KITTITAS COUNTY COMMUNITY DEVELOPMENT SERVICES

Subject: Wenger (SPF-18-00005) Final Short Plat – Staff Review and Request for Additional Information

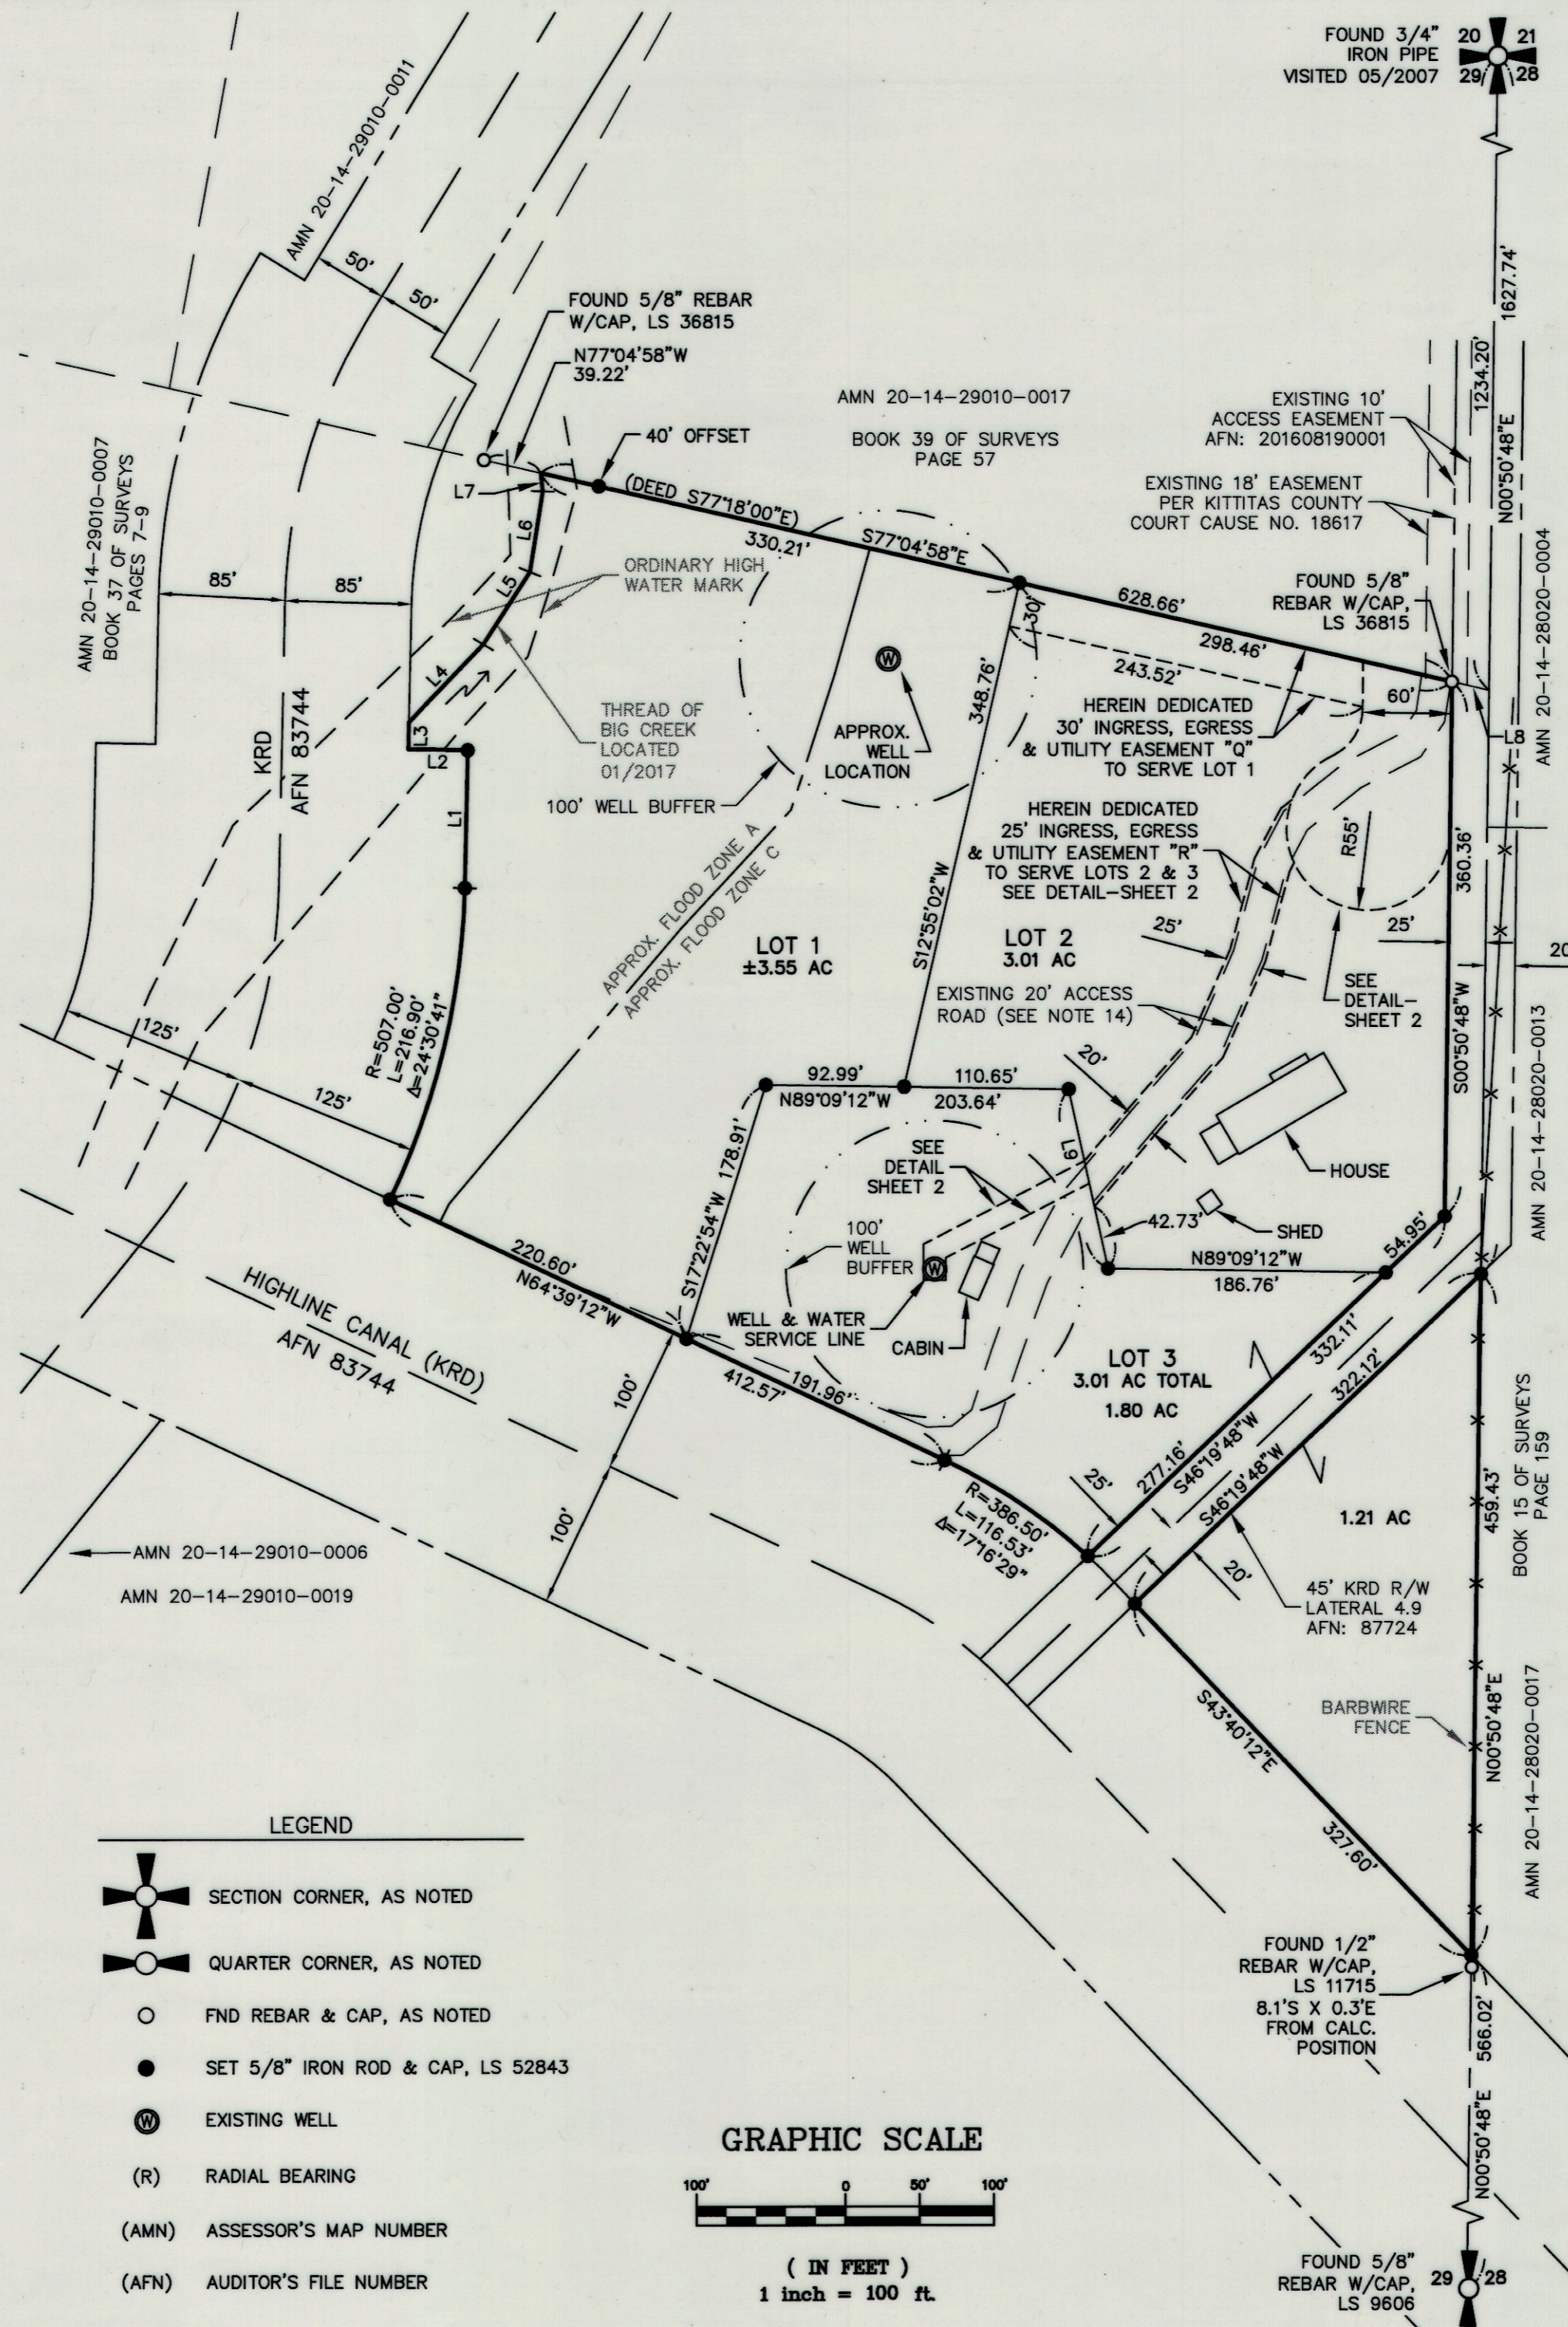
The submitted final short plat depicts the ordinary high watermark of Big Creek, but does not show the full 200' shorelines jurisdiction as requested nor does the final short plat depict the easement and driveway serving parcel 616536. Please revise the plat to depict the full shoreline jurisdiction and the easement and driveway serving parcel 616536.

Drawing file: SPF-18-00005 Wenger / SPF-18-00005 Wenger Final Plat with Easement Highlighted .pdf

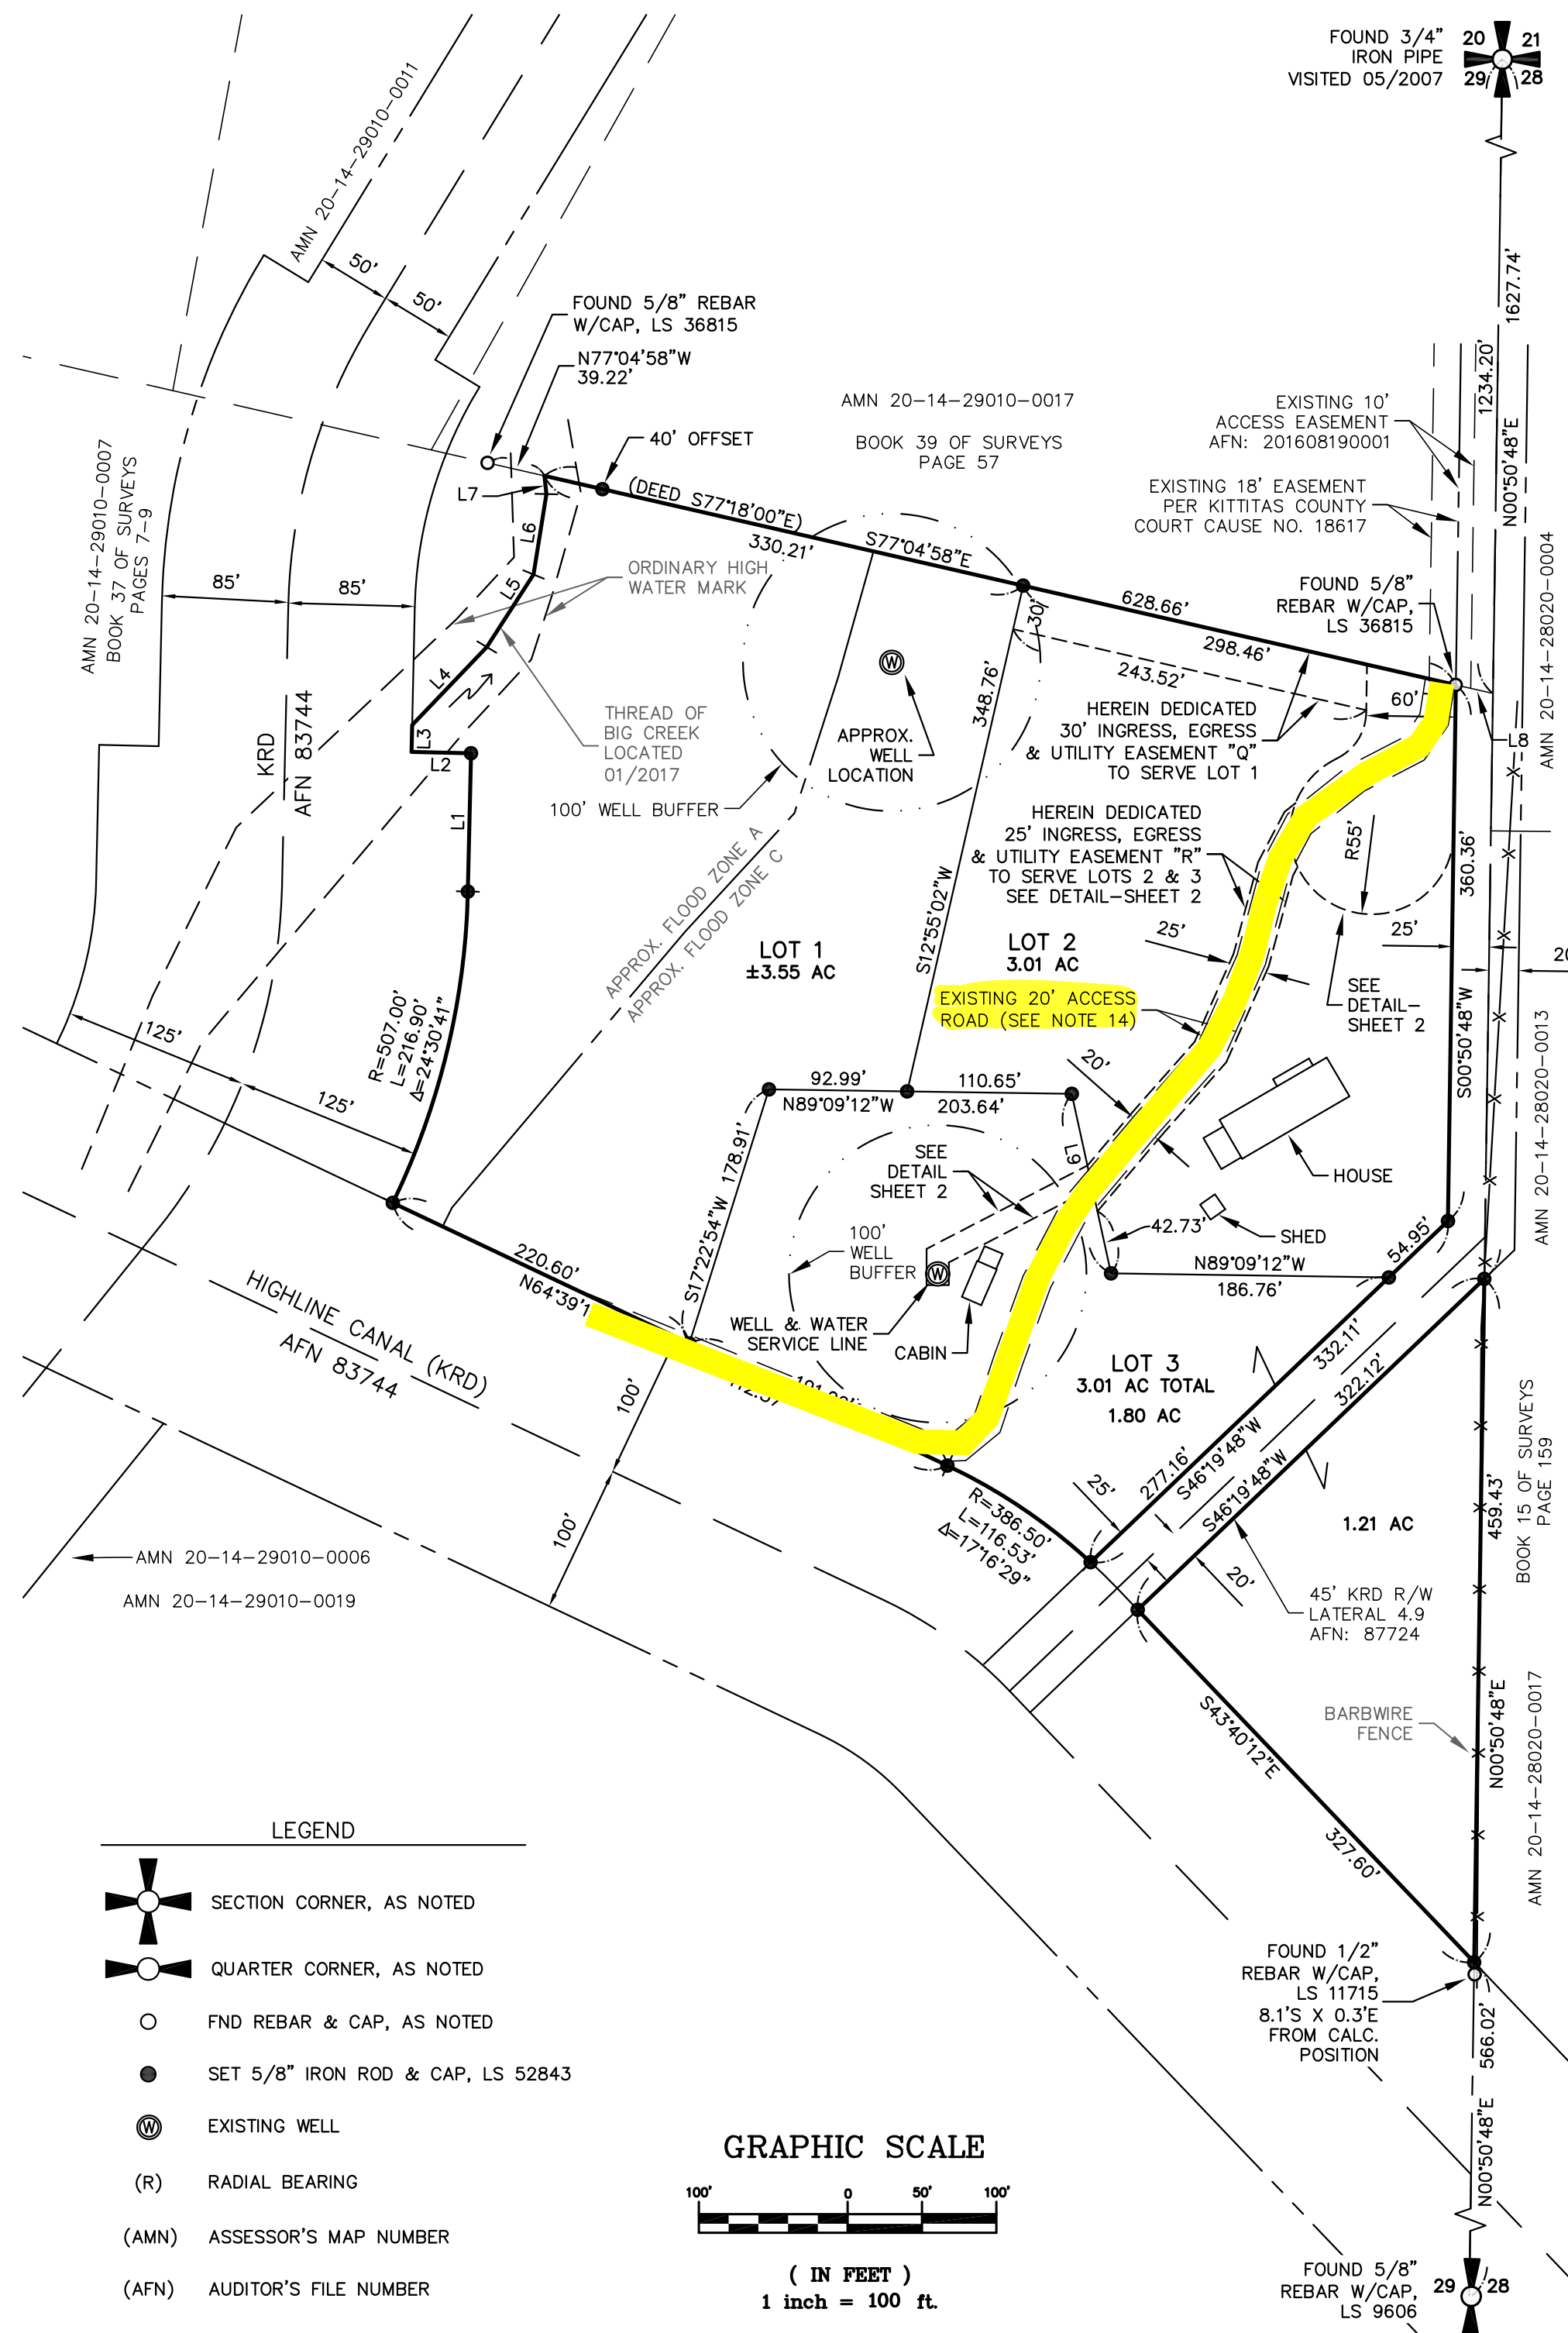
1. Please see attached memo dated September 24, 2018. The materials submitted do not address this requirement to the satisfaction of Public Works. The following items must be addressed:
 - a. The easement as shown on the plat does not depict the full access to parcel number 616536.
 - b. Please provide a private road certification of the road serving the plat.
 - c. Provide either 1) an access agreement from the Bureau of Reclamation with a term of at least 50 years, or 2) provide evidence that a longer agreement period cannot be obtained from Bureau of Reclamation.
